TRAILS AT ASPEN RIDGE - FILING NO. 5

8" PUBLIC SANITARY MAIN PLANS

AUGUST, 2026

DRAWING No.
TS01

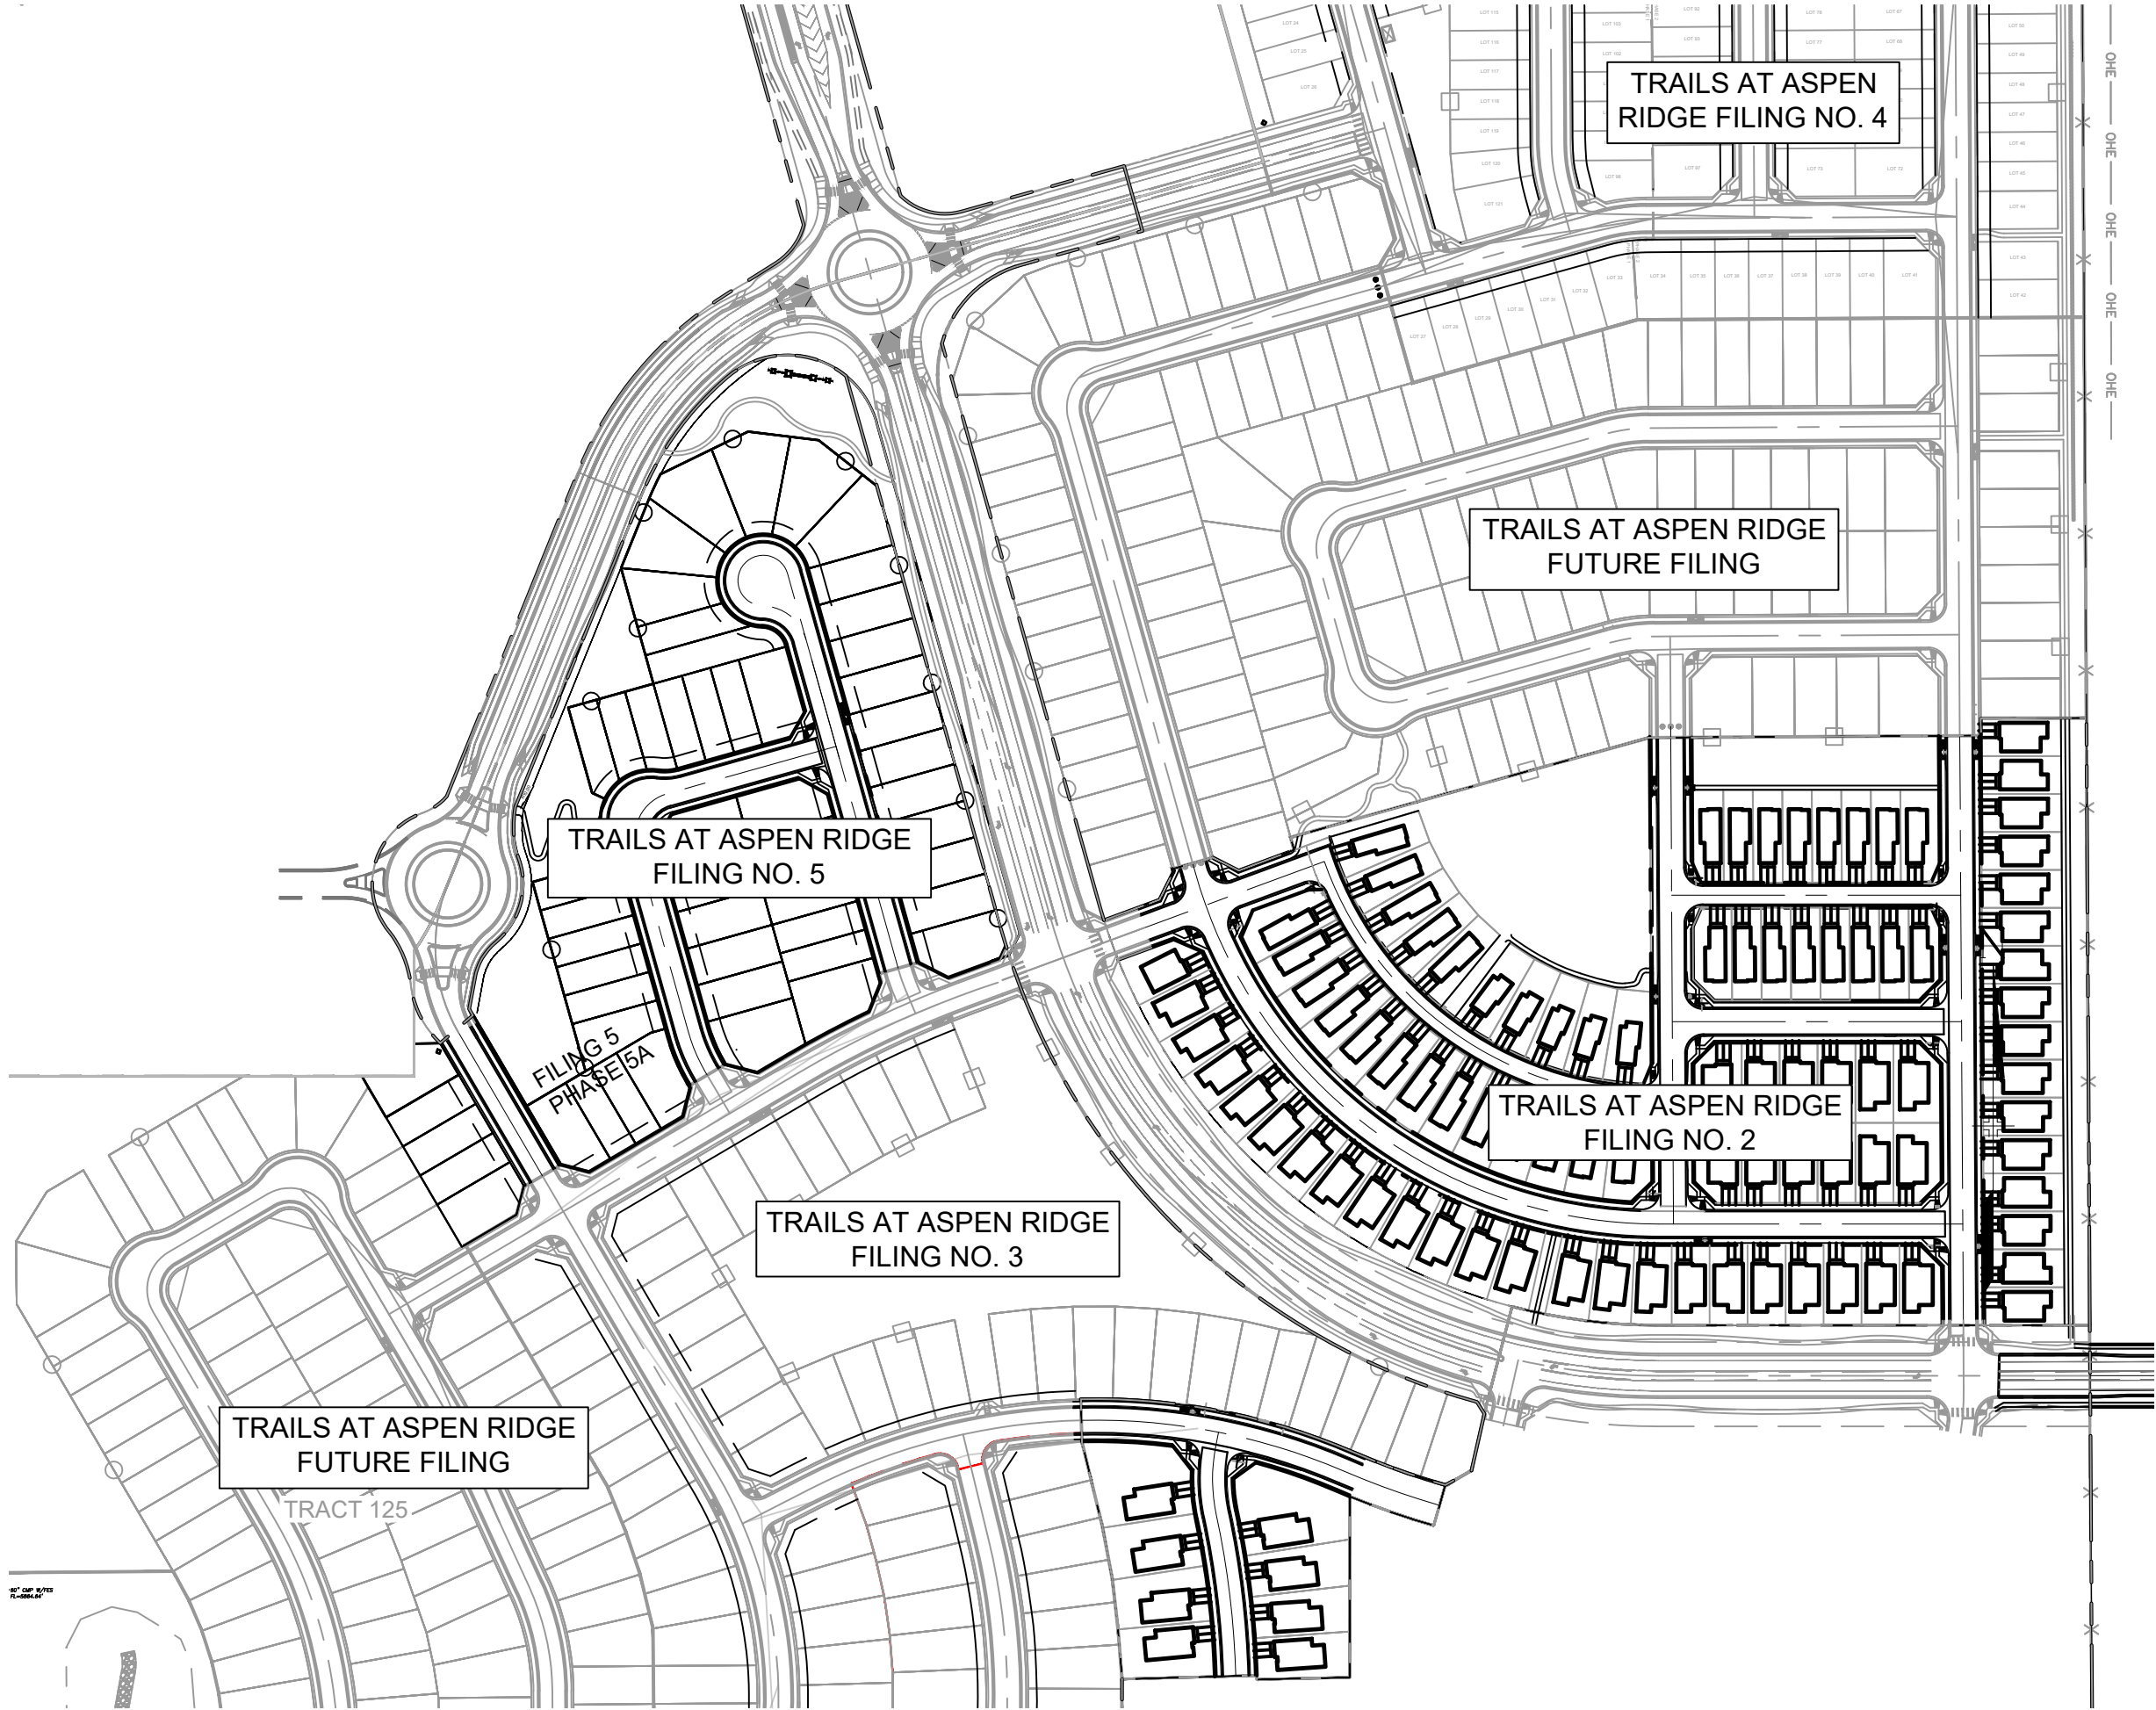
Robert is no longer the contact for WWSD, please use Lucas Hale's contact info.
